# CITY OF ALBUQUERQUE

August 28, 2024

**Re: Tidal Wave Auto Spa  
10601 Unser Blvd. NW  
30-Day Temporary Certificate of Occupancy  
Transportation Development Final Inspection**  
Architect's Stamp dated 04-05-23 (A11-D017C)  
Certification dated 08-22-24

AS101

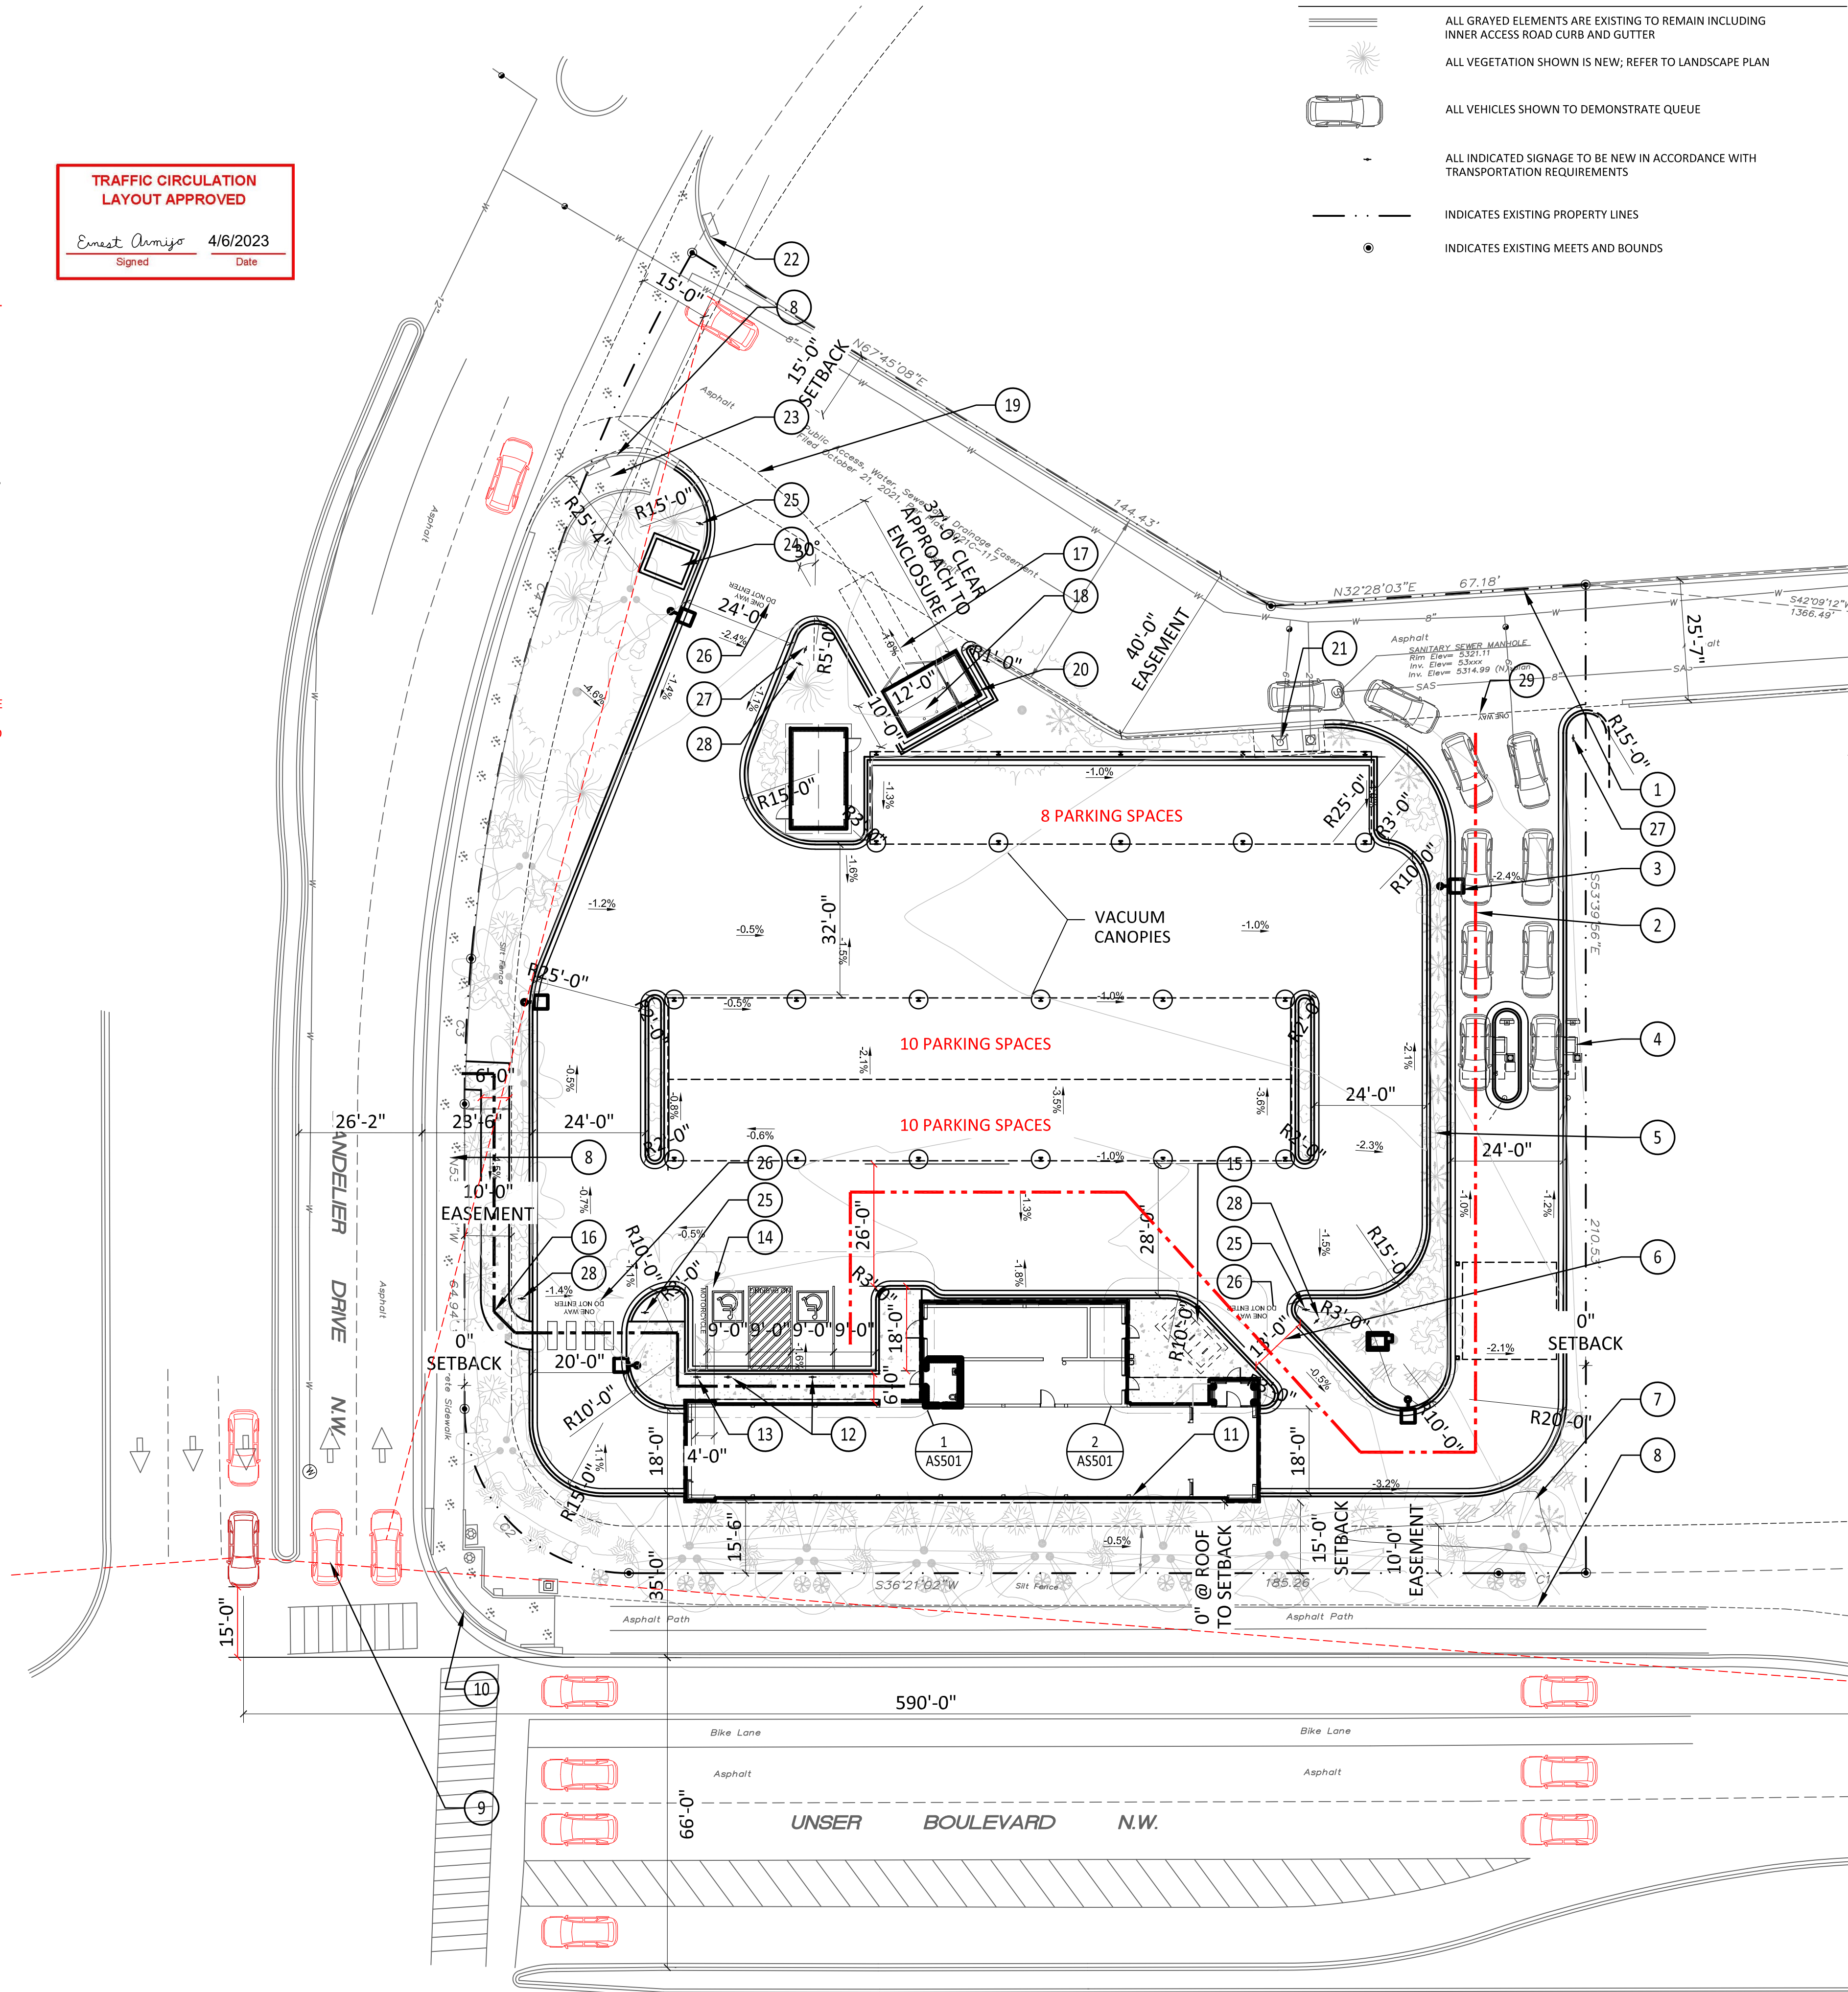
- The construction of the ADA pathway from the public sidewalk to the building entrance must be finished.
